Our ref: New Rouse Hill Hospital (SSD-96248991)

Subject: Response to Submissions

The exhibition of the development application and environmental impact statement (EIS) for the New Rouse Hill Hospital (SSD-96248991) ended on 10 December 2025.

**DRAWING TITLE**  
 SSDA - SITE PLAN PROPOSED

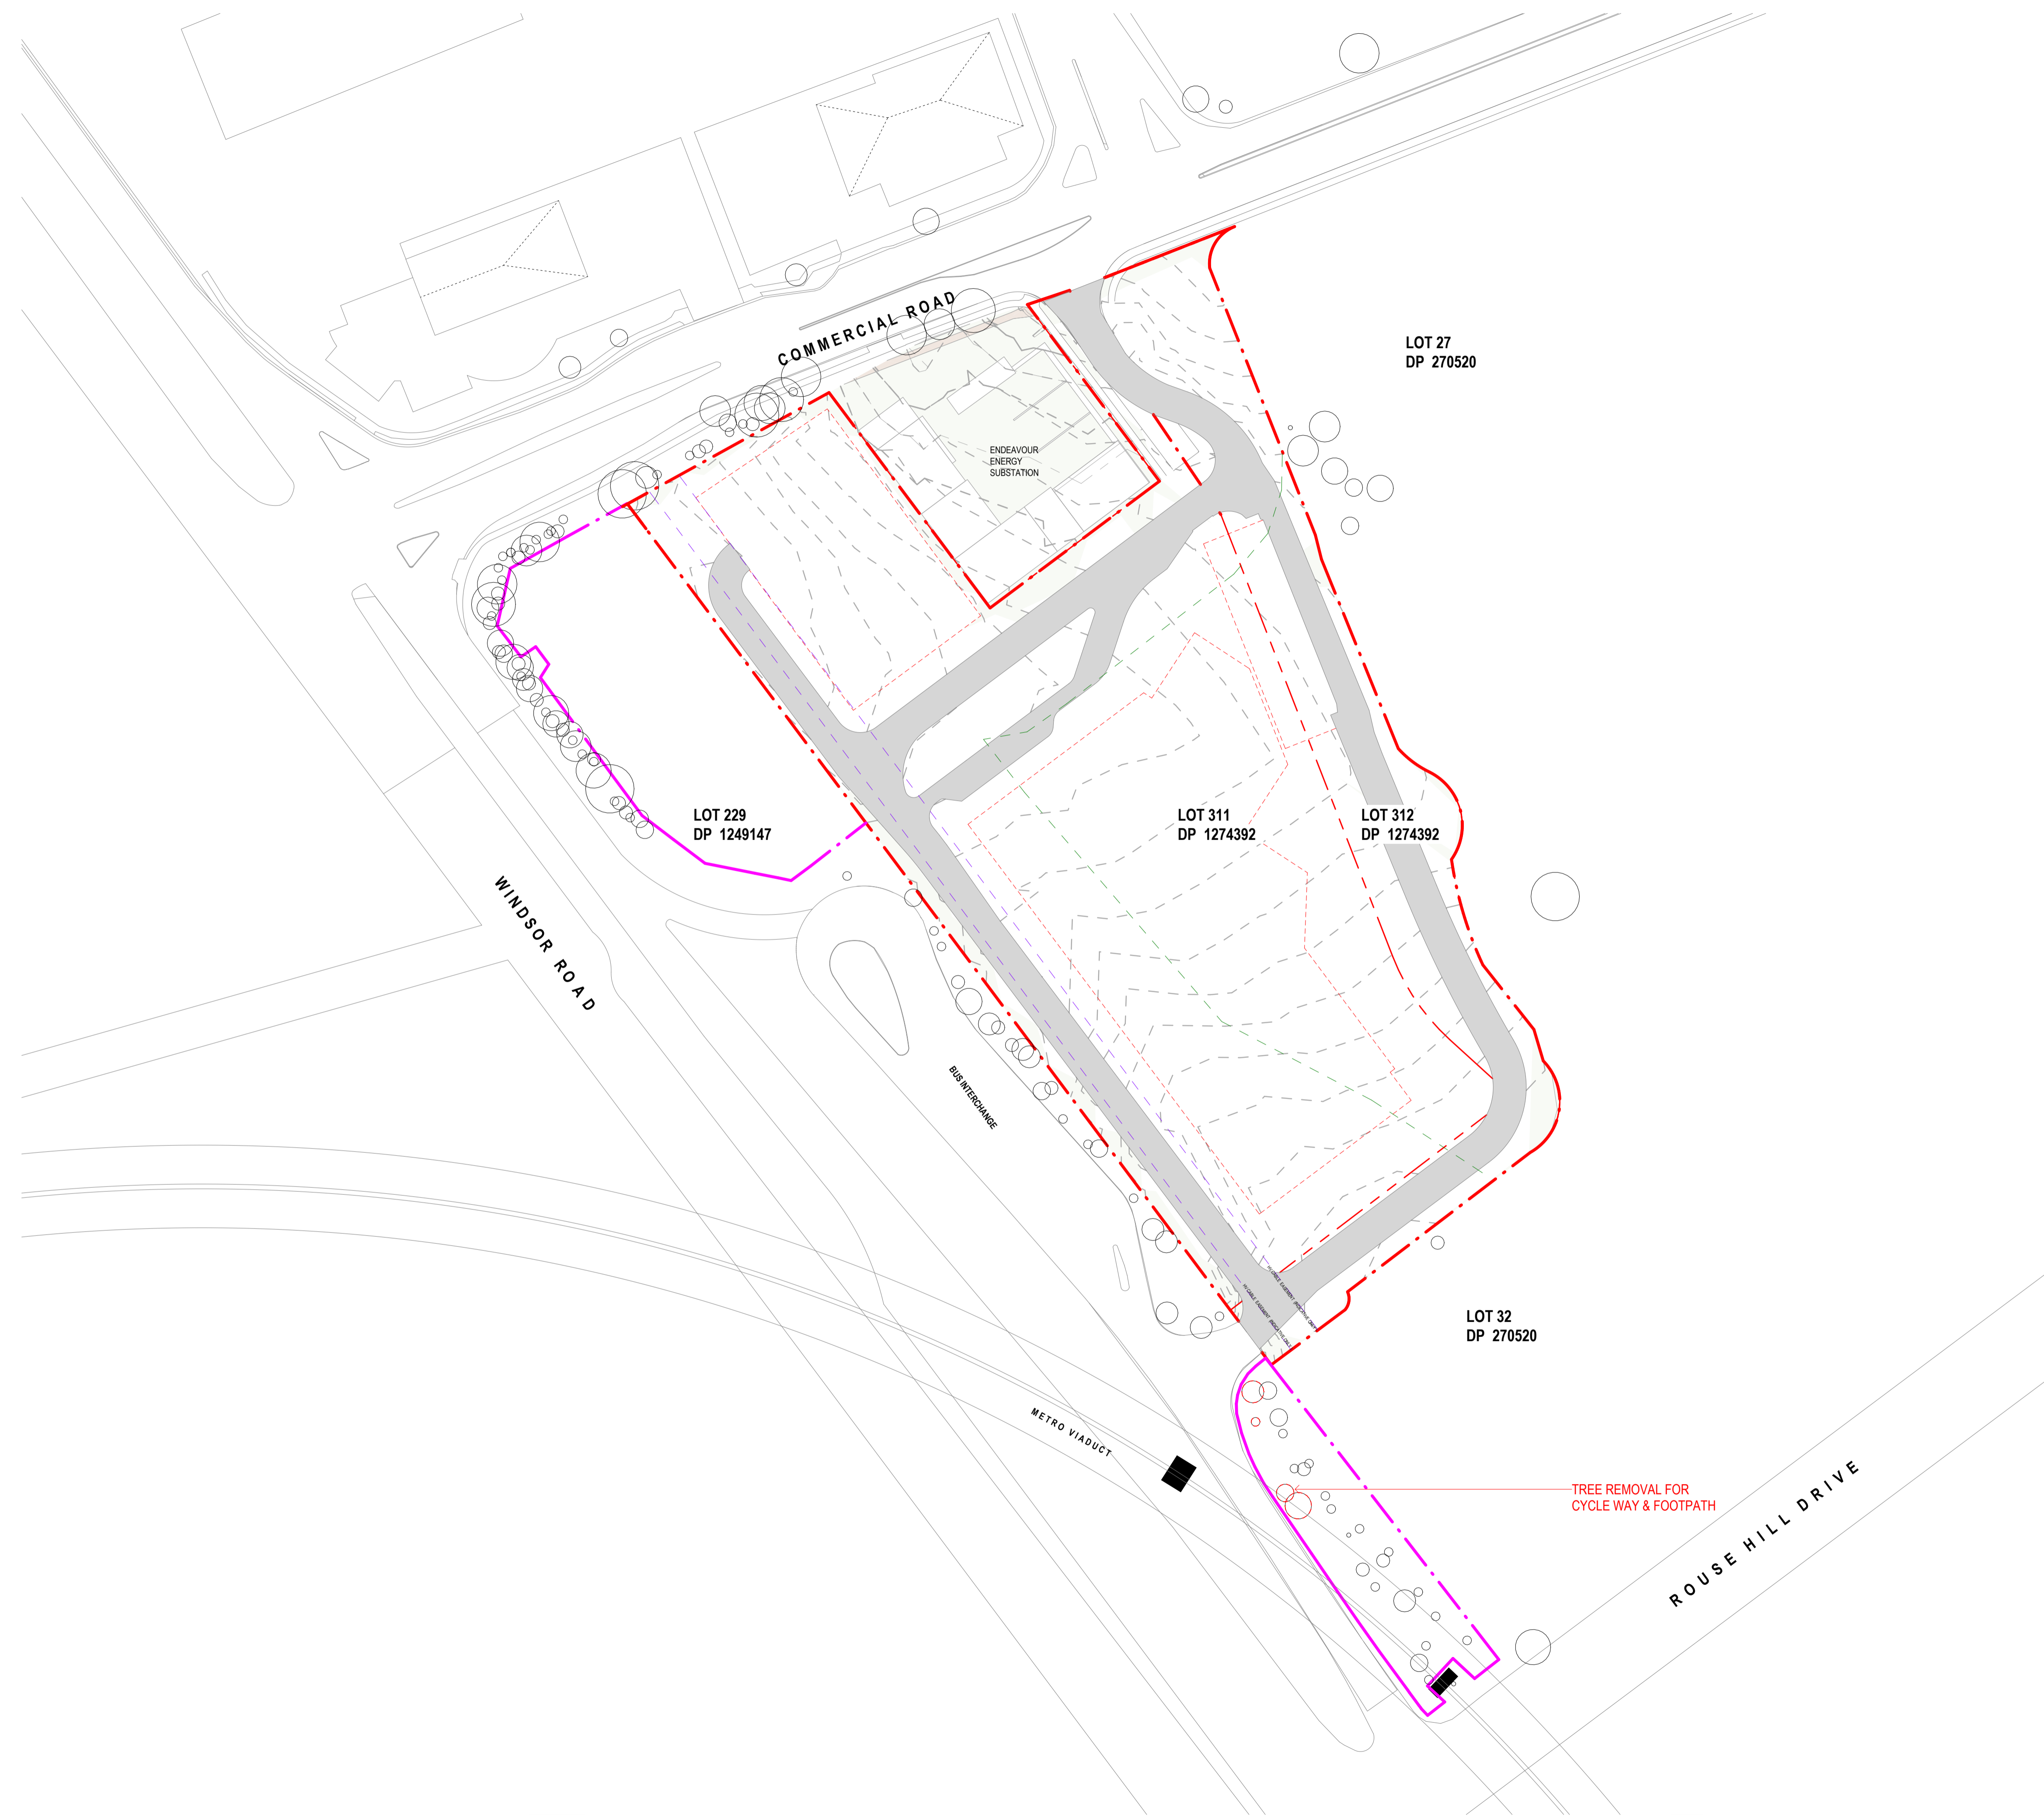
- The drawing *SSDA-Site Plan Proposed* shows the provision of site sheds on Lot 229 DP 1249147 (corner of Windsor Rd and Commercial Rd). The Landscape Plans appear to indicate the same. The Department considers that the site sheds should be removed upon completion of the works with this area being appropriately treated/finished. Clarification is sought on the intended outcome for this parcel of land.
